WEST SUSSEX COUNTY COUNCIL CONSULTATION

TO:	Arun District Council FAO: Anita Gardner
FROM:	WSCC - Highways Authority
DATE:	24 February 2021
LOCATION:	4 Beechlands Close & east of 18 Montpelier Road East Preston BN16 1JZ
SUBJECT:	EP/10/21/PL Demolition of an existing garage & erection of 2 No. 2 bed dwellings (resubmission following EP/115/20/PL). This site is in CIL Zone 4 and is CIL Liable as dwellings.
DATE OF SITE VISIT:	n/a
RECOMMENDATION:	Advice
S106 CONTRIBUTION TOTAL:	n/a

18 BEECHLANDS COURT, EAST PRESTON, BN16 1JZ	
Client	Description
c/o RSP ARCHITECTS LTD	PROPOSED SITE PLAN

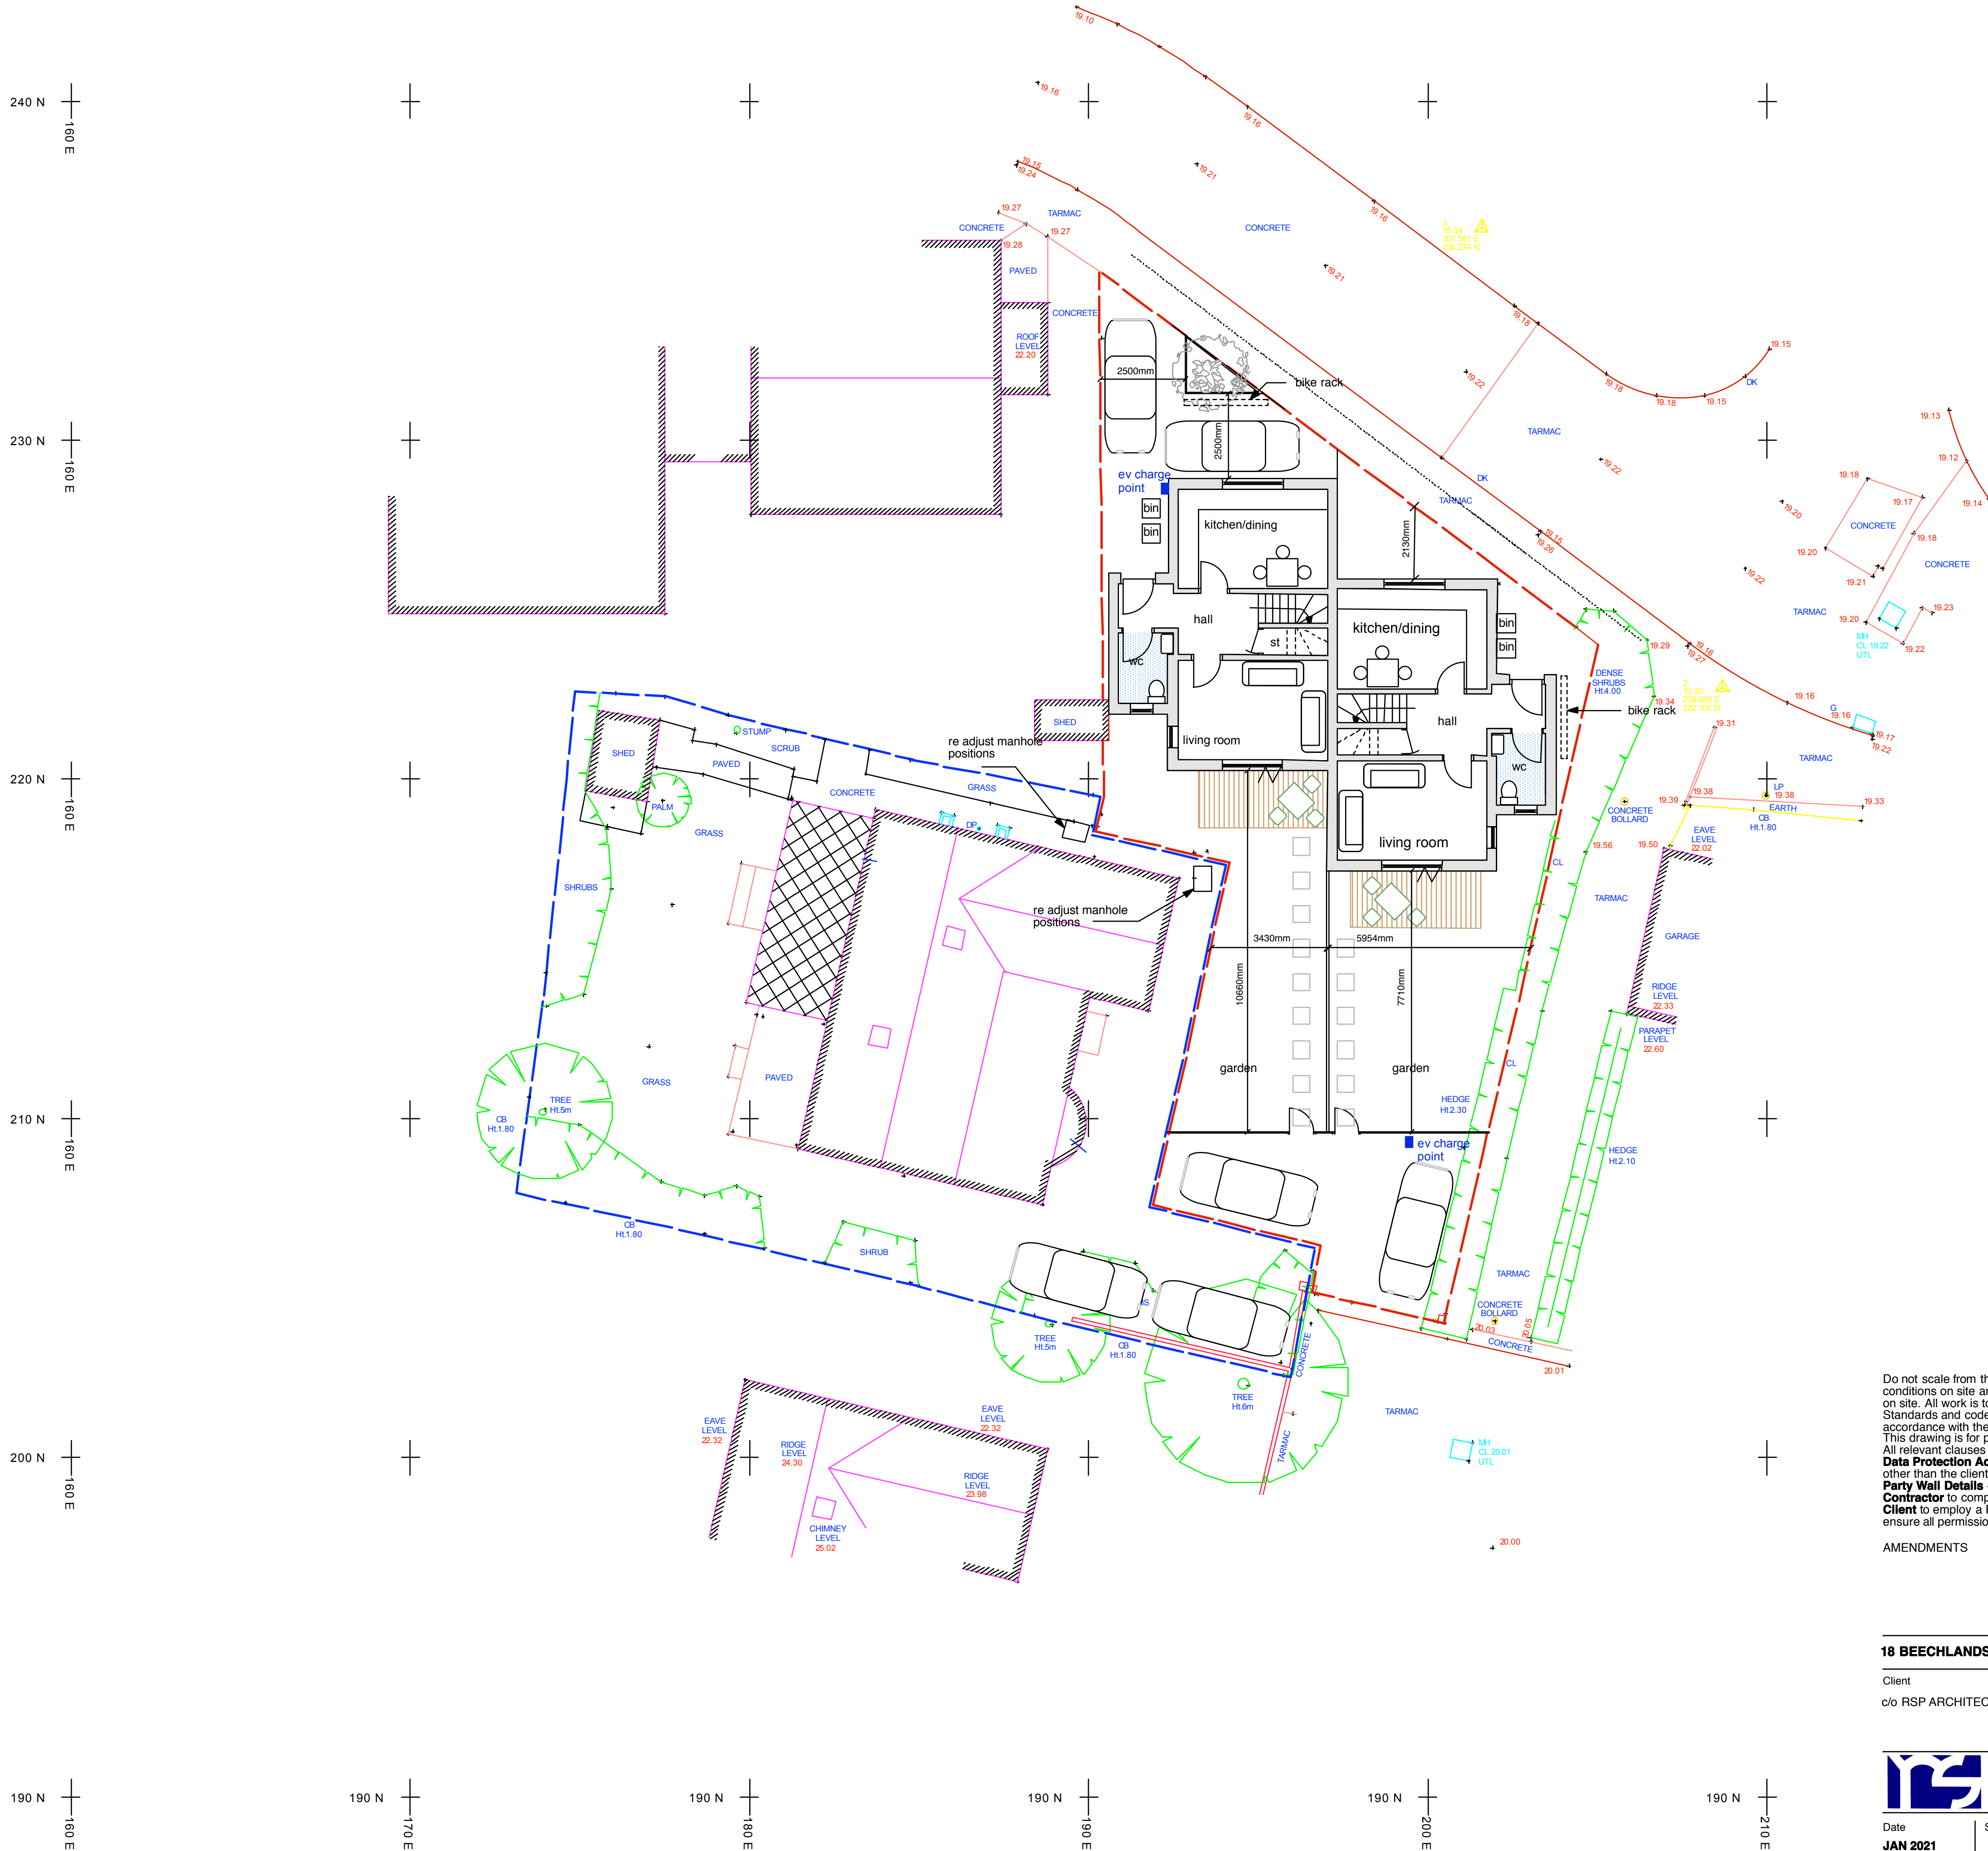
The applicant proposes to implement a new access to the north for one dwelling while utilising the existing access to the south for the 2nd dwelling. Neither access have been supported with visibility. However, given the nature of the two roads and advice given in manual for streets for urban areas. The LHA raise no concerns over this provision.

The applicant should be made aware that a 2nd VCO onto the same property are generally not accepted at the licensing stage. Though in this instance, such a provision is not considered a highway safety concern. The applicant should be mindful that this may result in, if successful, a planning permission that cannot be implemented. Therefore, the

applicant is recommended amending the plans to show a single VCO of between 4.5 – 6.4 metres. Details of which can be secured via a suitably worded condition.

The applicant proposes to provide 4 parking spaces (2 each). Arun parking standards outline that 2 spaces each are required. The proposed provision meets this demand, providing these can be kept with the above access alterations.

No details pertaining to covered cycle parking are provided. As per the Arun Parking Standards, the LHA wish to see cycle storage implemented in the form of lockable covered storage. Details of which can be secured with a suitably worded condition found below.

The Applicant has provided basic details for EV parking which do not state the quantity of the provision. As such the LHA requests as per Arun's Parking Standards that EV parking to 100% of parking spaces are provided. Details of which can be secured with a suitably worded condition found below.
